From: Richard Stefanski
Sent: 09 July 2021 09:5
To: Amber Willard
Cc: Alex Baxter
Subject: RE: br/143/21/clp

I am just writing up BR/143/21/CLP at 140 London Road.

Drawing Title:
PROPOSED PLANS AND ELEVATIONS

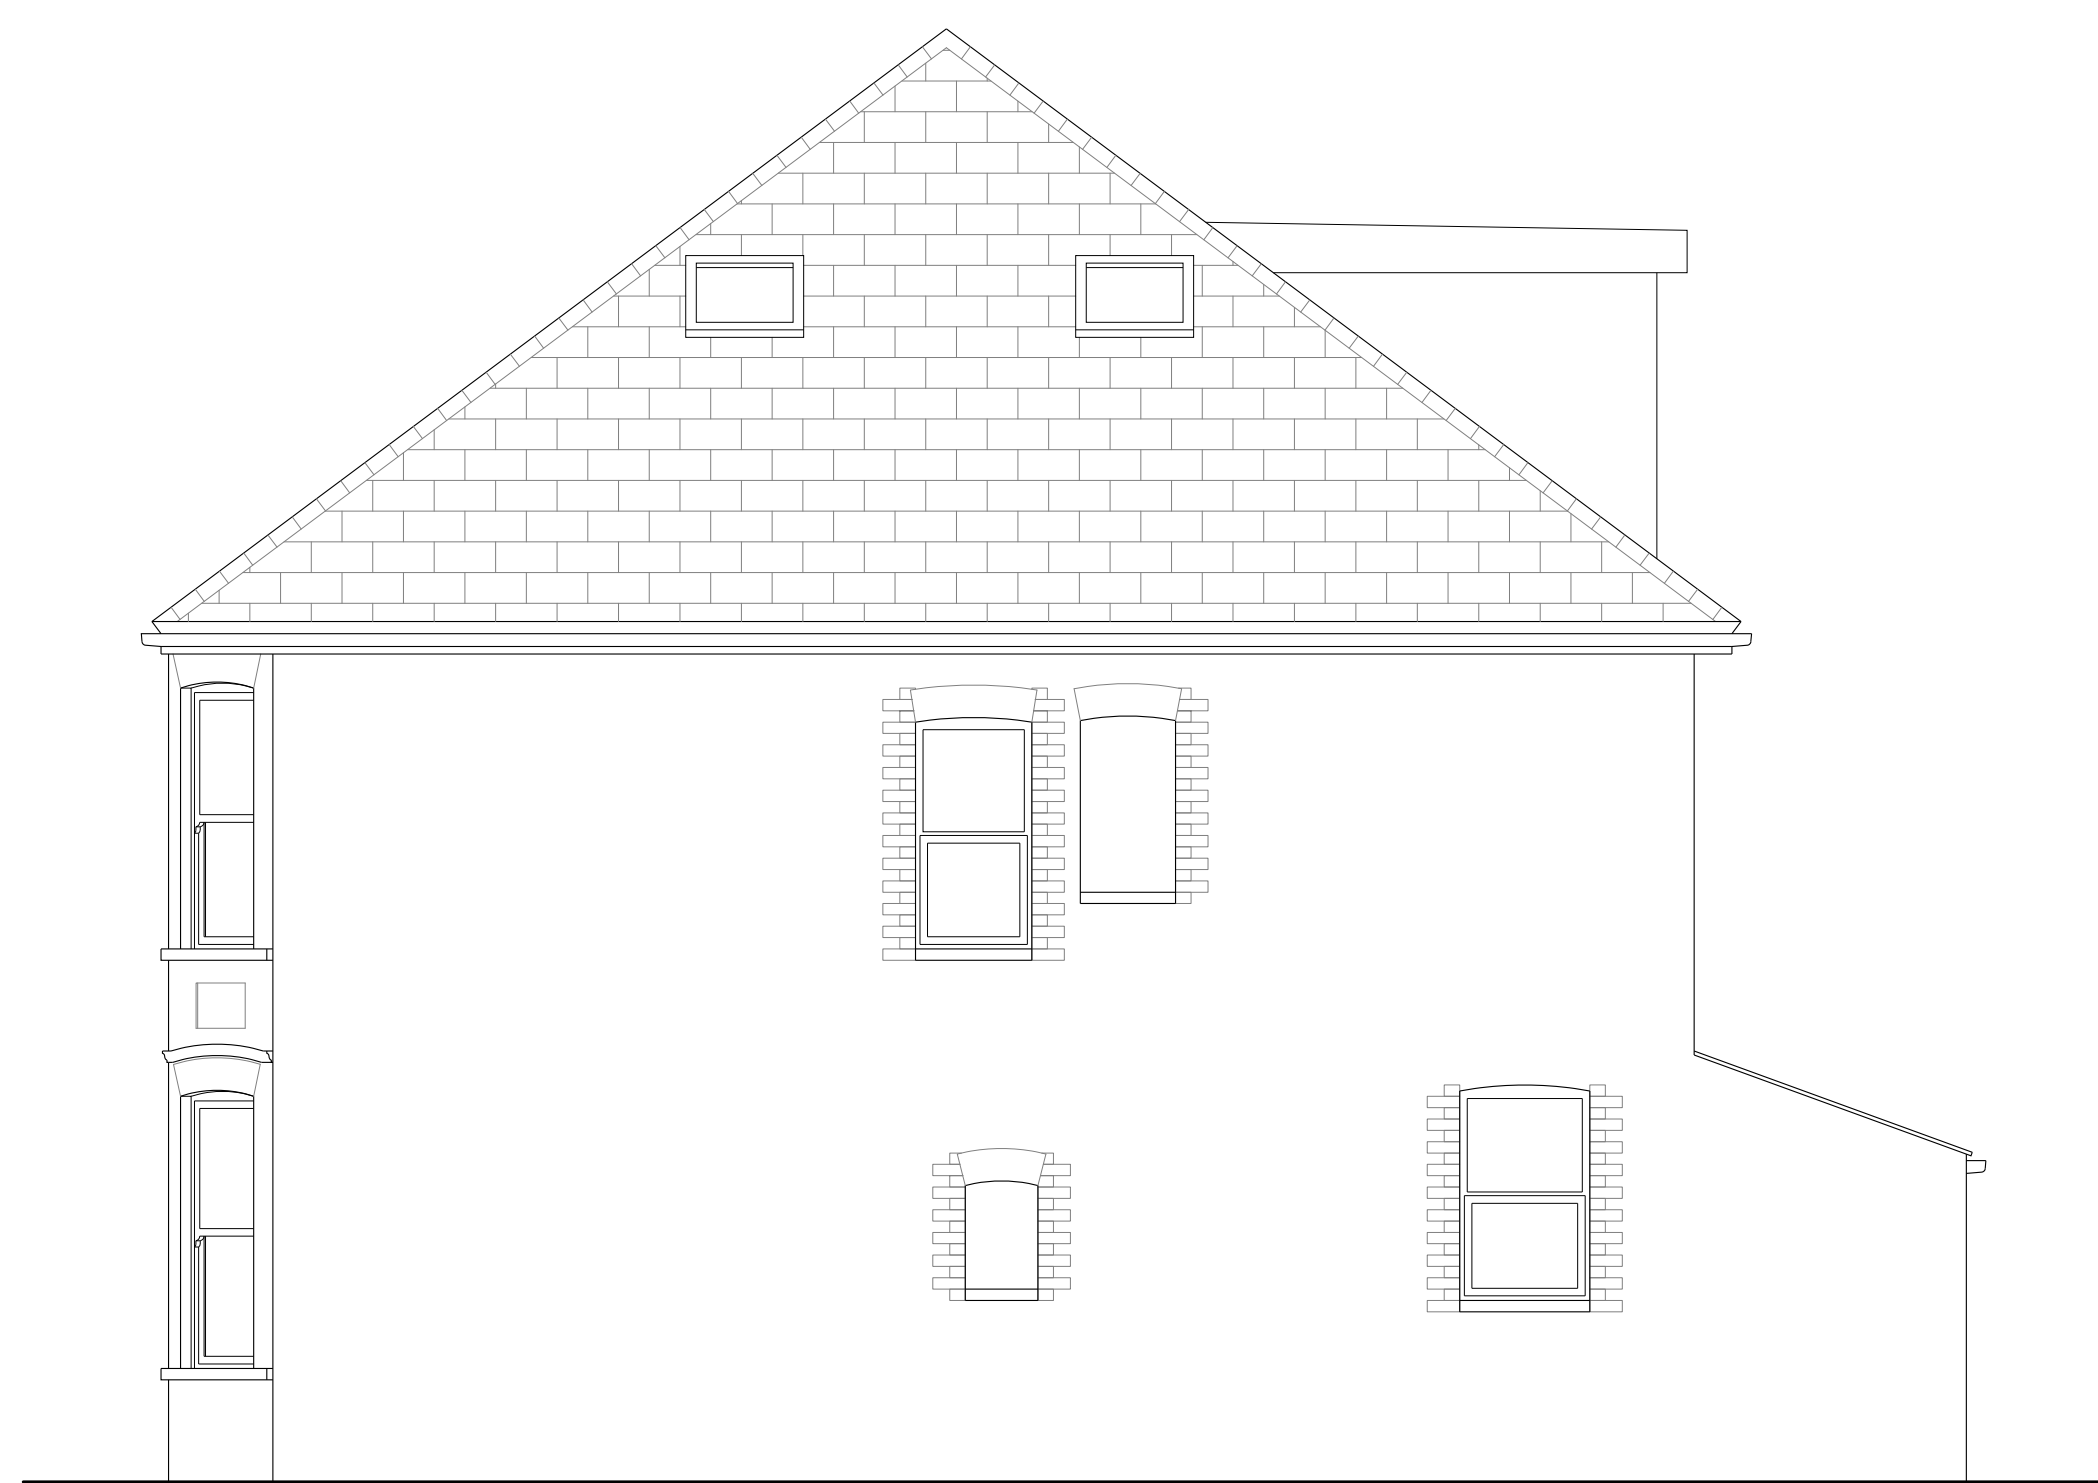
Please can you confirm that the rooflights on the side elevation will be obscured glazed to comply with

(c) any window inserted on a wall or roof slope forming a side elevation of the dwellinghouse must be (i) obscure-glazed, and (ii) non-opening unless the parts of the window which can be opened are more than 1.7 metres above the floor of the room in which the window is installed.

Please also confirm that the

(a) the materials used in any exterior work must be of a similar appearance to those used in the construction of the exterior of the existing dwellinghouse;

- Any window inserted on a wall or roof slope forming a side elevation of the dwellinghouse will be obscure-glazing and non-opening unless parts of the window which can be opened are more than 1.7 meters above internal finished floor level.
- The materials used in any exterior work will be of a similar appearance to those used in the construction of the exterior of the existing dwellinghouse.
